DEVELOPMENT REVIEW BOARD

Re: City of Albuquerque Fire Station 2 – Project # 1008786: Response to EPC Notice of Decision

OFFICIAL NOTIFICATION OF DECISION

FILE: Project # 1008786
11EPC-40029 AMNDT TO ZONE MAP (ZONE
CHG)
11EPC-40031 SITE DEVELOPMENT- BUILDG
PRMT

LANDSCAPE PLAN
1" = 20'
0 20' 40'

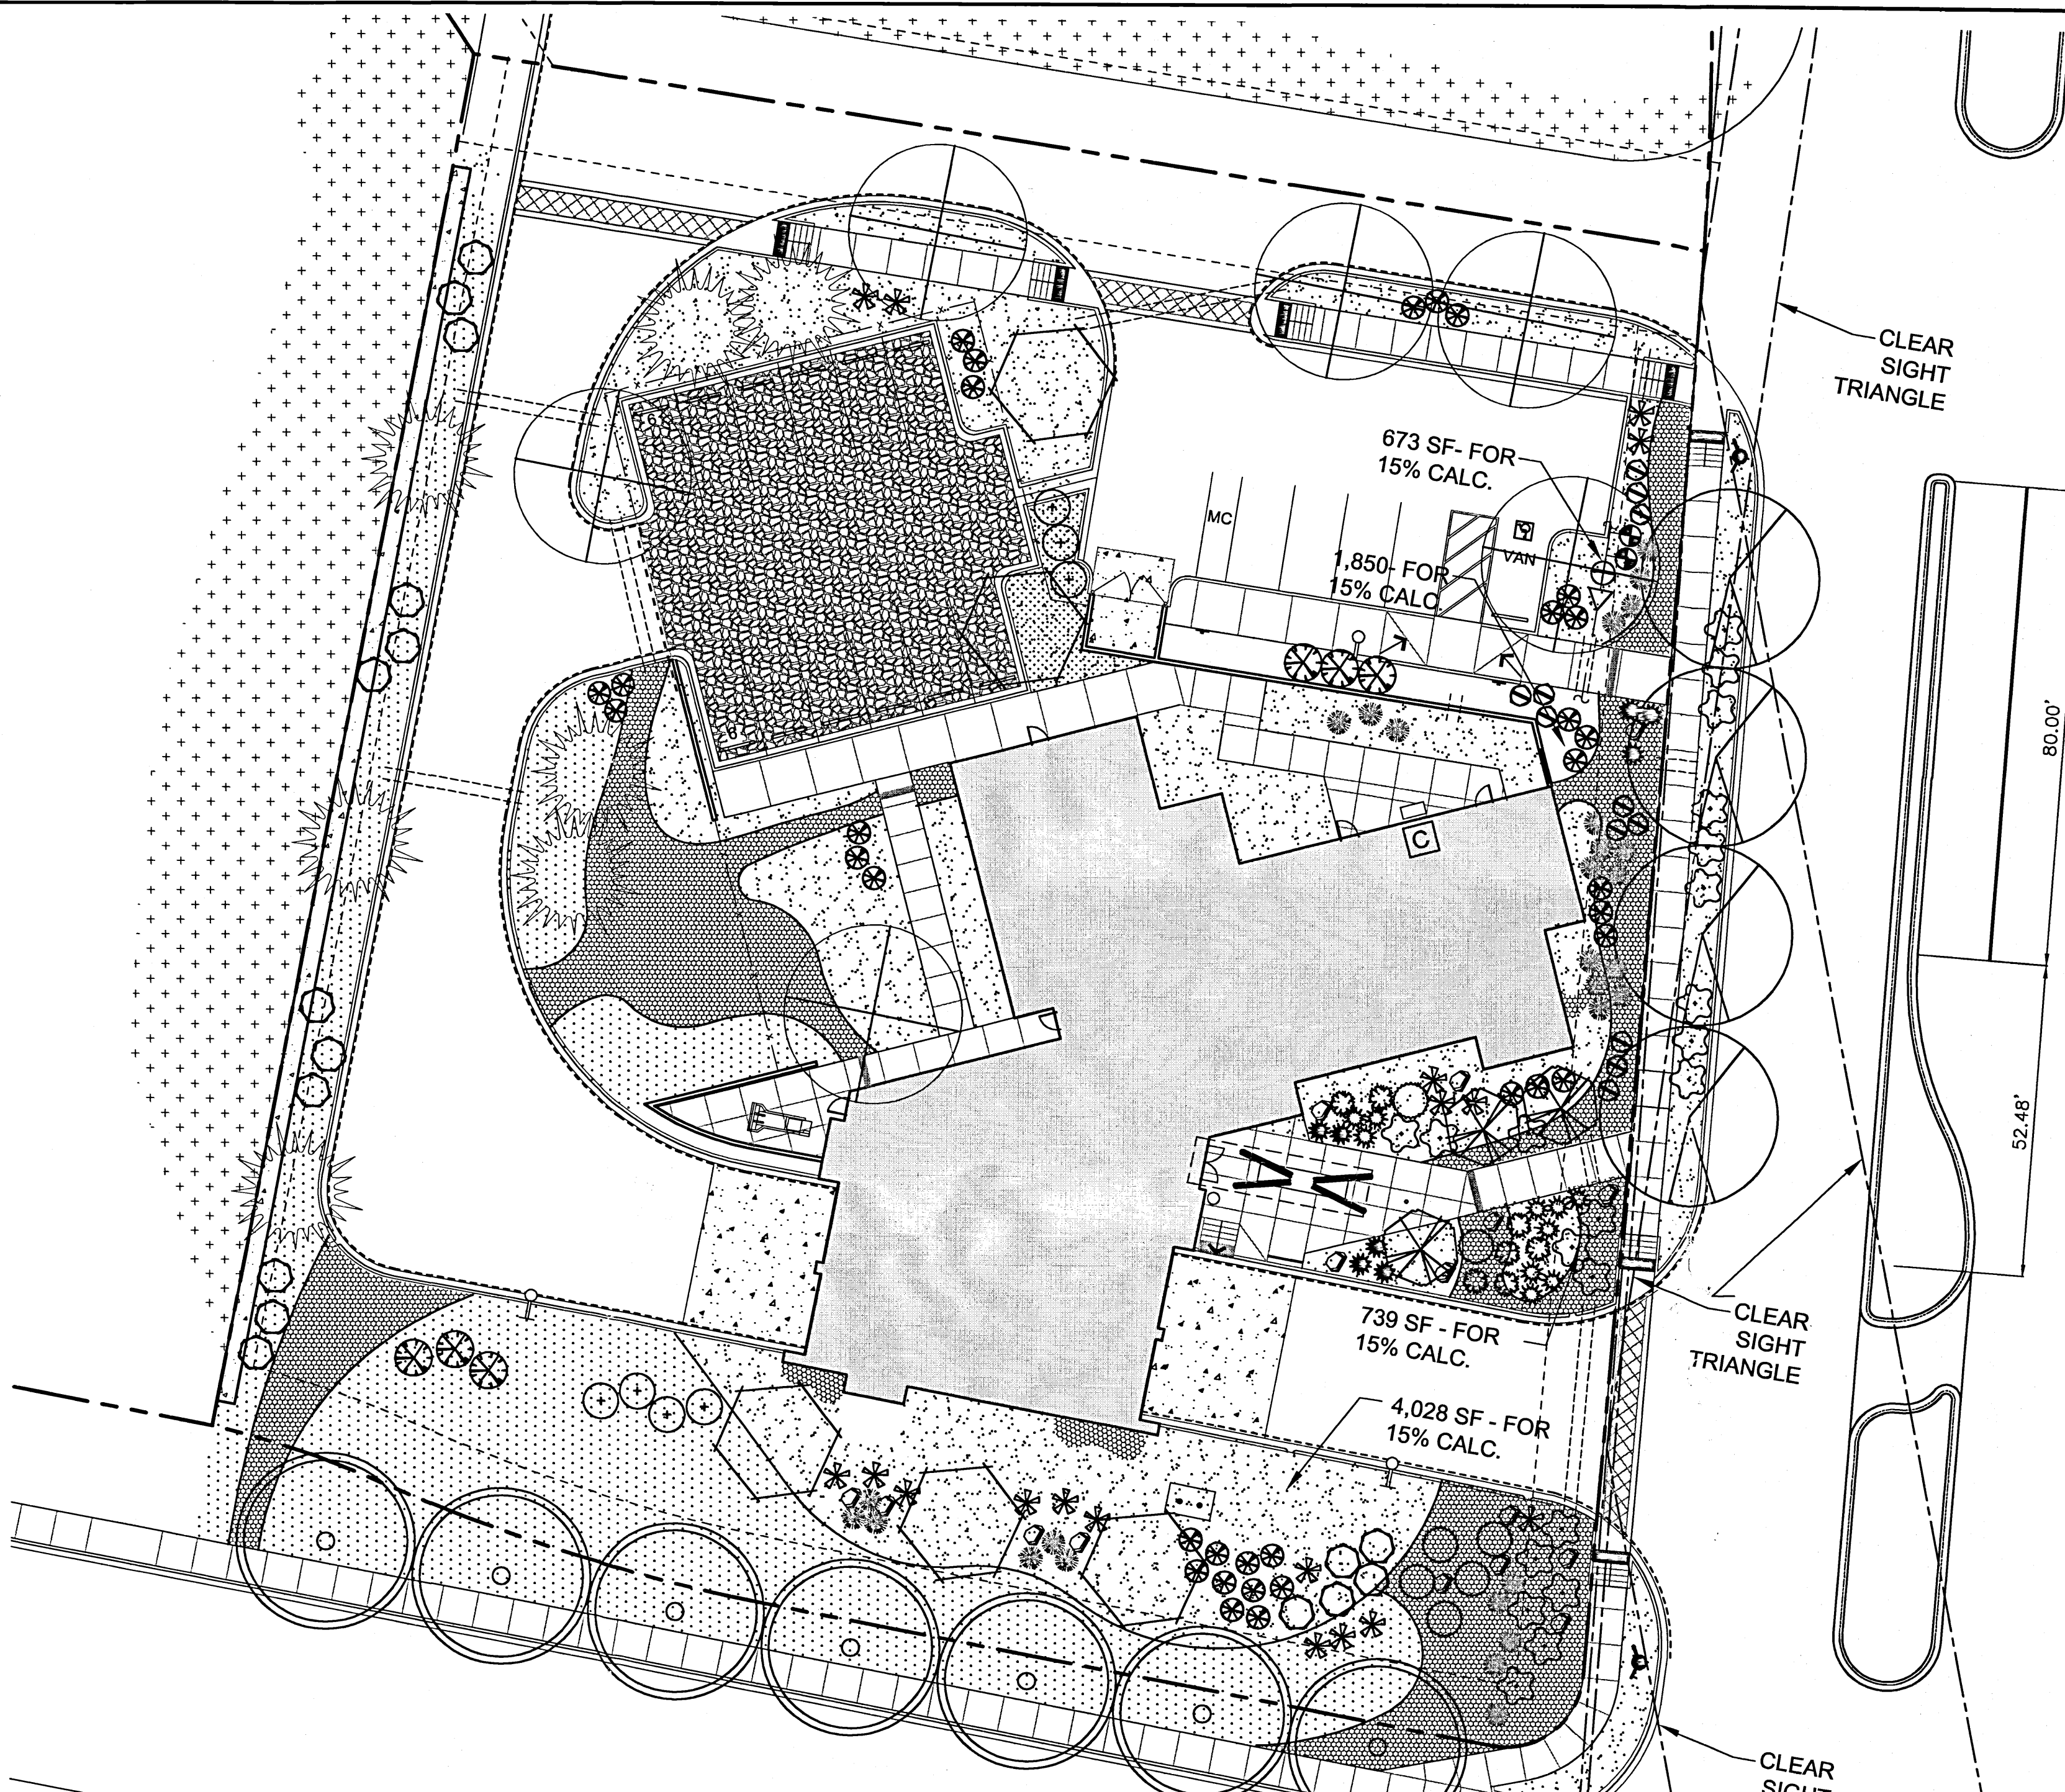
- b. A detail for a bicycle rack shall be shown on the site details sheet.
 - c. Scored concrete shall be used to connect sidewalk along West Road to improve access from Gibson Boulevard to the public patio.

- 4b. A bicycle rack detail is shown on the submittal.
 - 4c. Scored concrete has been added to connect sidewalk along West Road.
 - 5a. All infrastructure within the City ROW will be provided by UNM, per the land exchange agreement. Public infrastructure is being addressed in the separate site development plan for subdivision action submitted by UNM.
